DRB Application No.: 10DRB-70039 Project # 100-11613
Project Name: LANDS OF RAYMOND & CAROL DURAN
Agent: STEVE BUTTERWORTH Phone No.:

CITY OF ALBUQUERQUE
PLANNING DEPARTMENT
February 10, 2010
DRB Comments

RE: Tracts A-1 and B-1, Lands of Raymond & Carl Durand

PLAT OF TRACTS A-1 AND B-1 LANDS OF RAYMOND AND CAROL DURAN

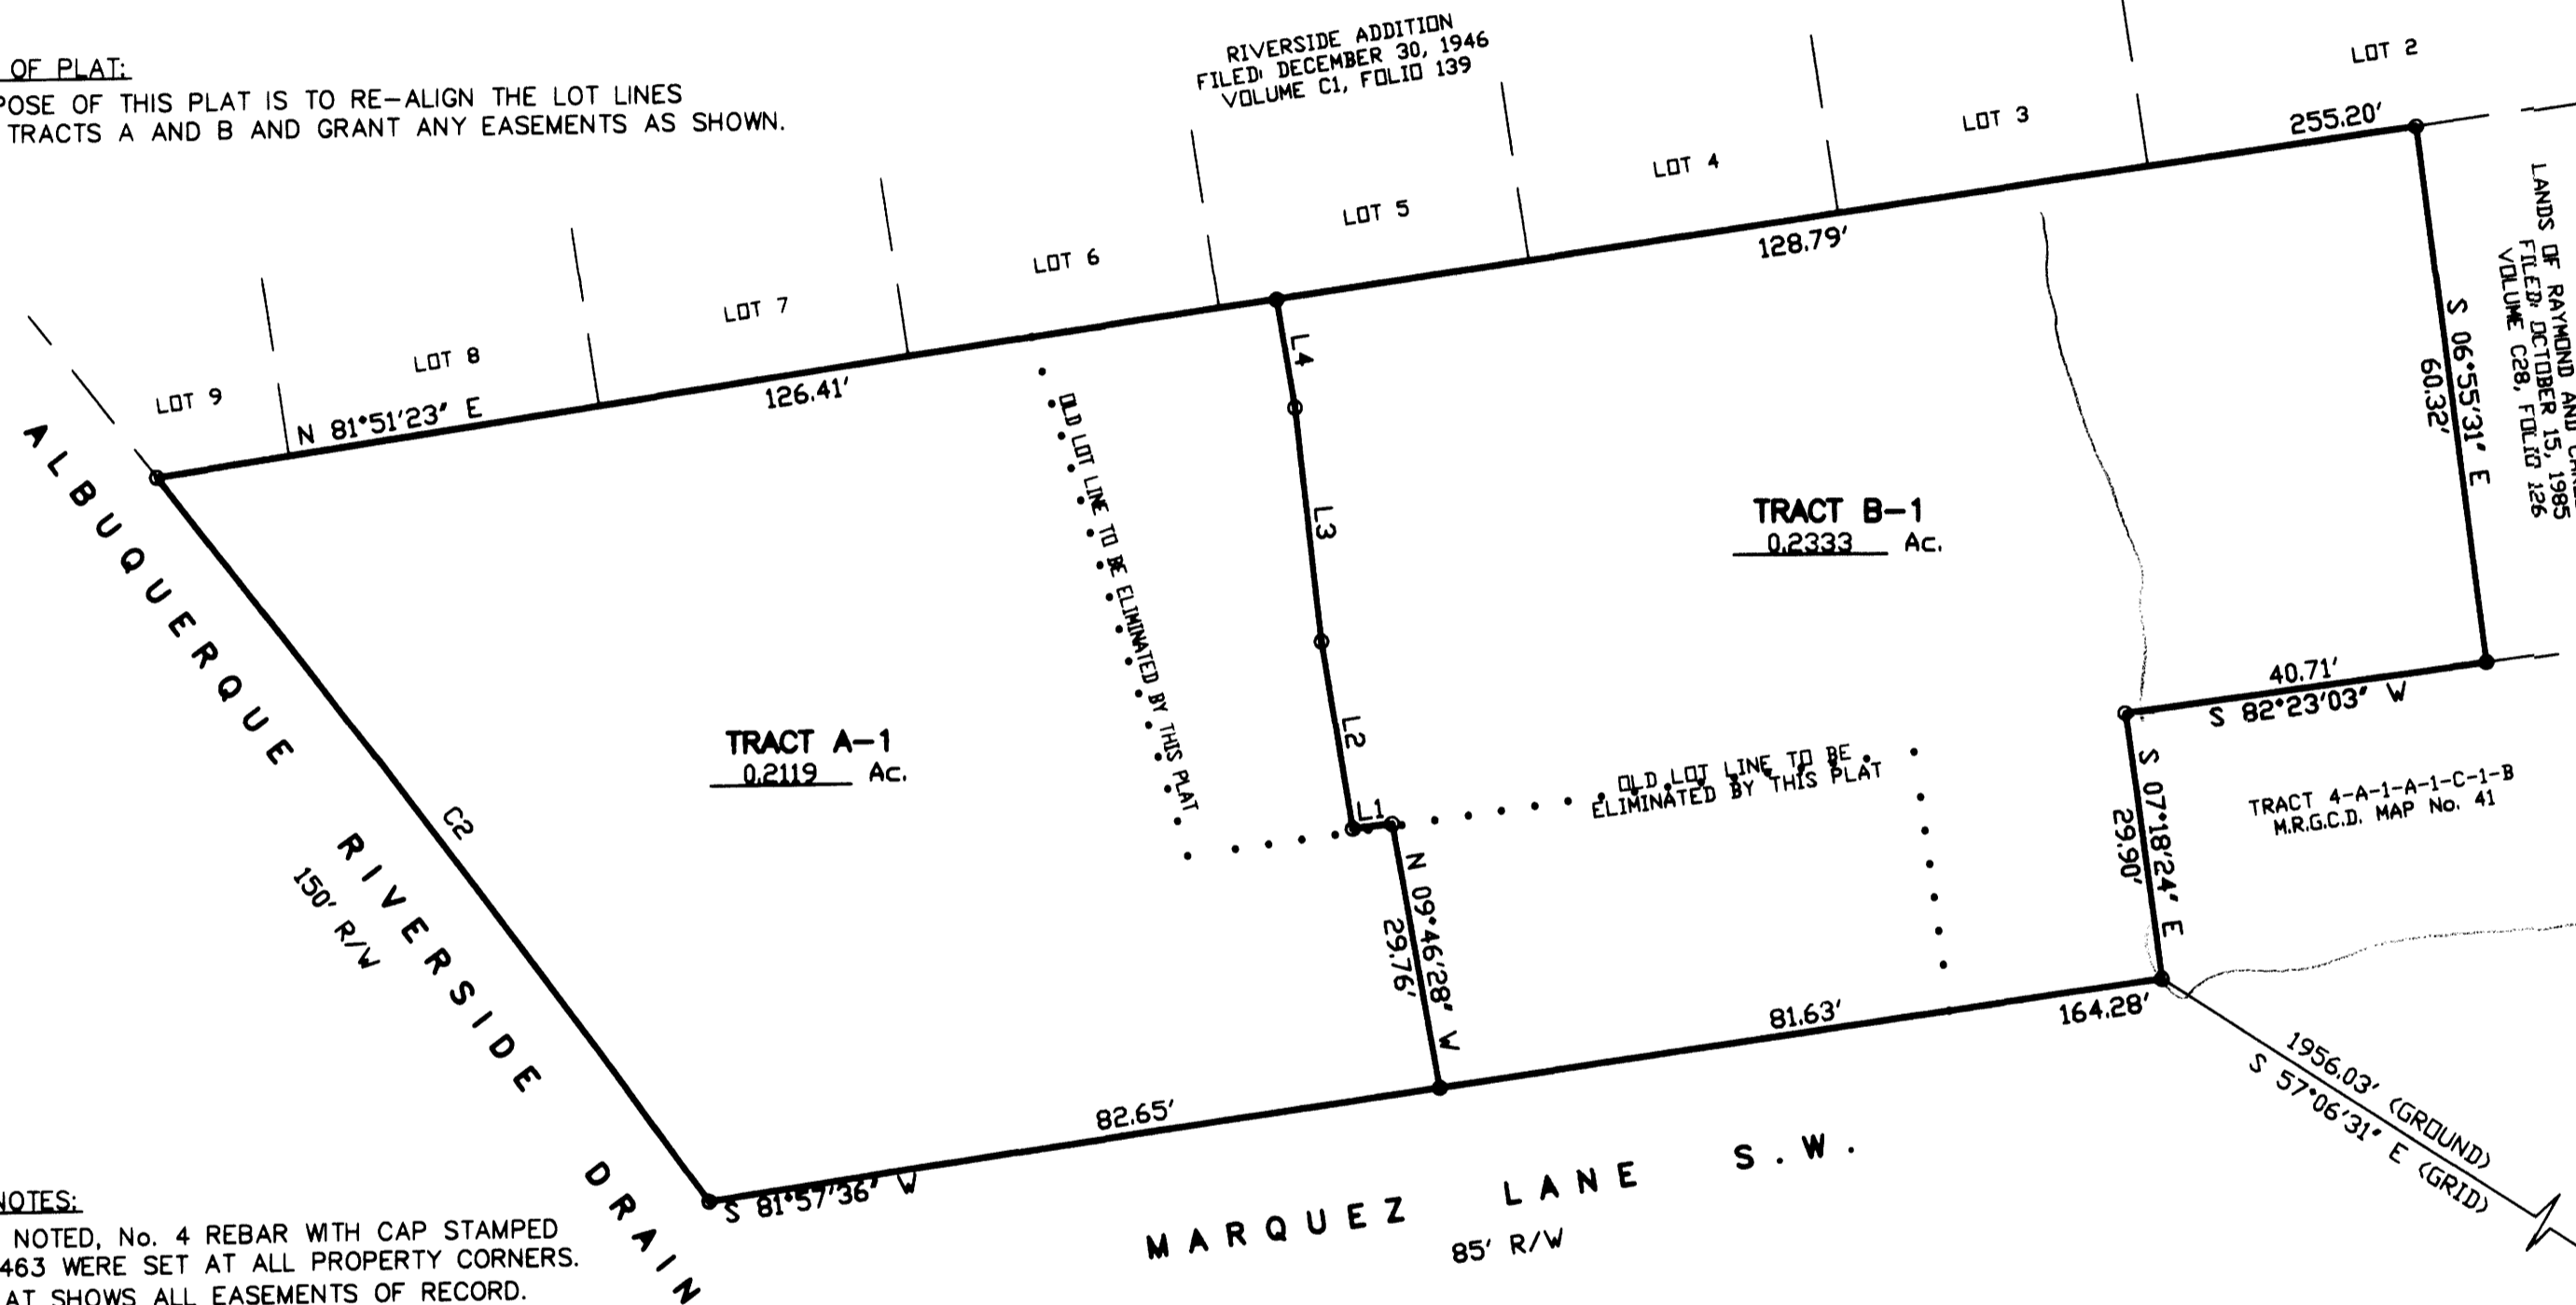
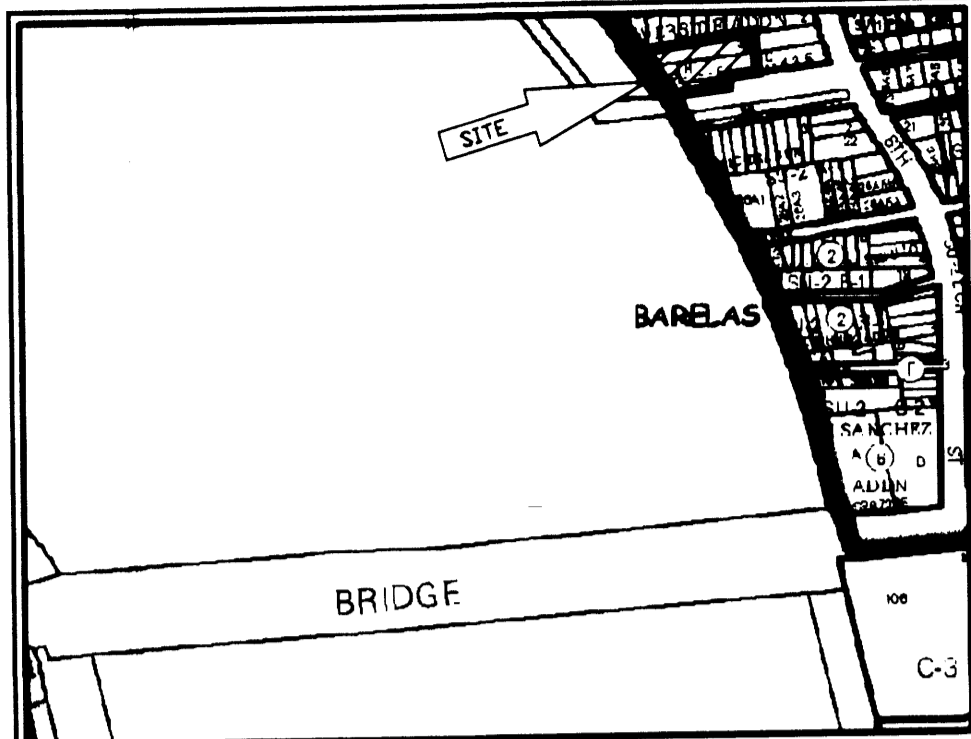
TRANSPORTATION: *- Exhibit showing curb cut and R.O.W*

PLANNING (Last to sign): *clarify eastern most building locations and revise plat accordingly*

- 1) Is the curb and gutter, sidewalk (width?) in place fronting both properties?
- 2) What is the distance from face of curb to the property line?

Based on the 2008 aerial photograph, there appears to be a structure that is partially on the eastern portion of Tract B. It appears the adjoining property will need to be included on this plat, with an adjustment to the property line such that appropriate setbacks are provided.

PLAT OF TRACTS A-1, B-1 AND D LANDS OF RAYMOND AND CAROL DURAN

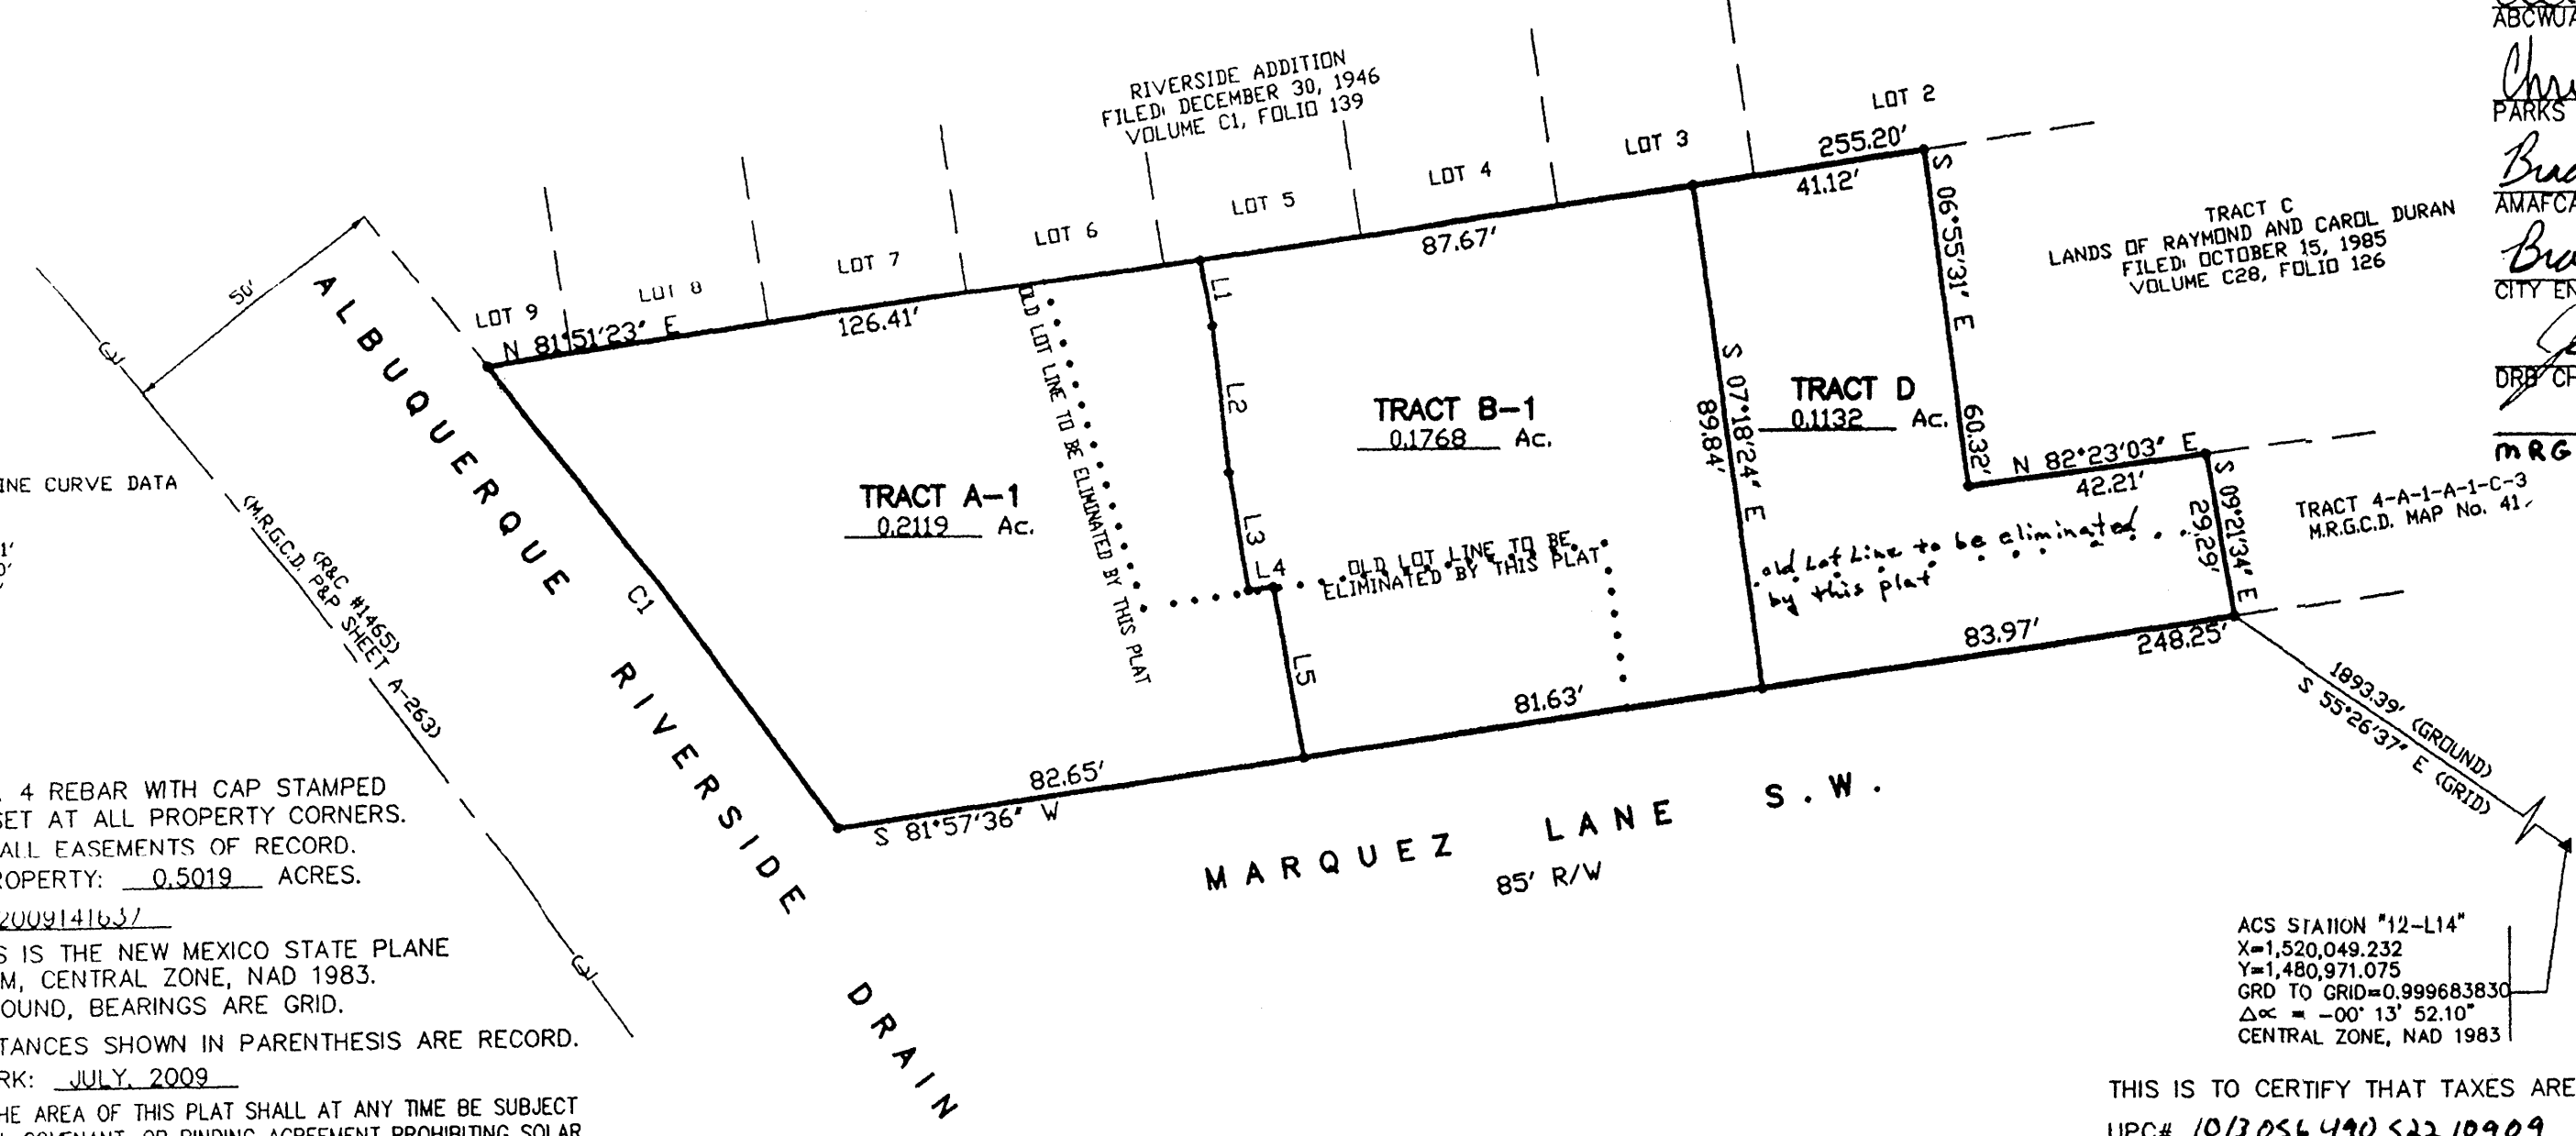
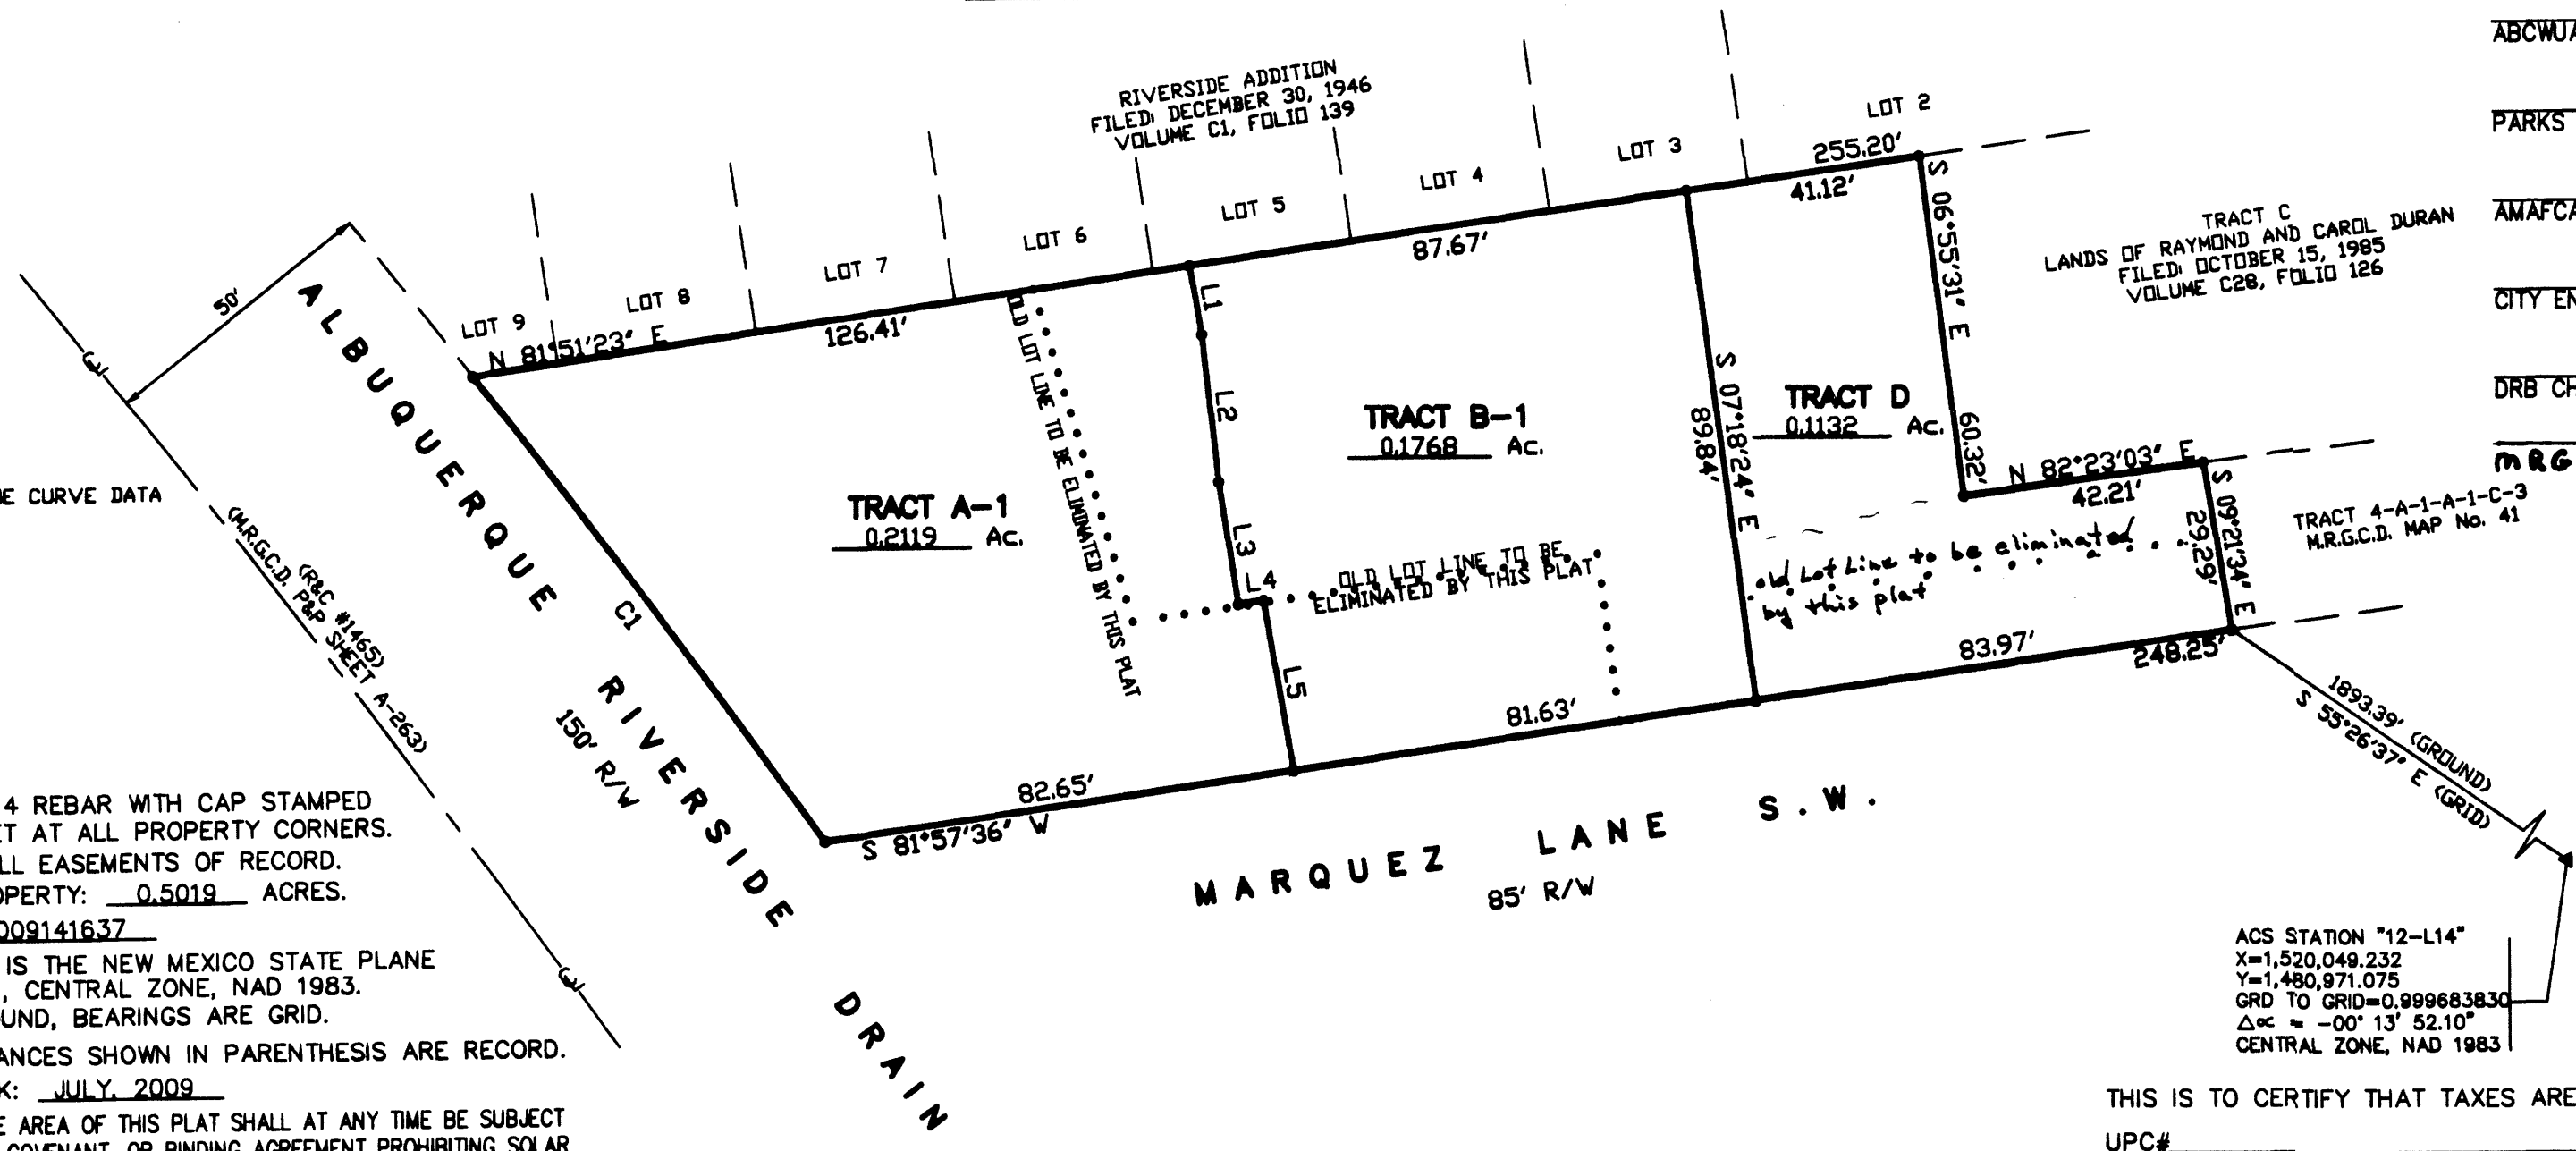
TRANSPORTATION: - revised exhibit

PLANNING (Last to sign): - revised / updated exhibit
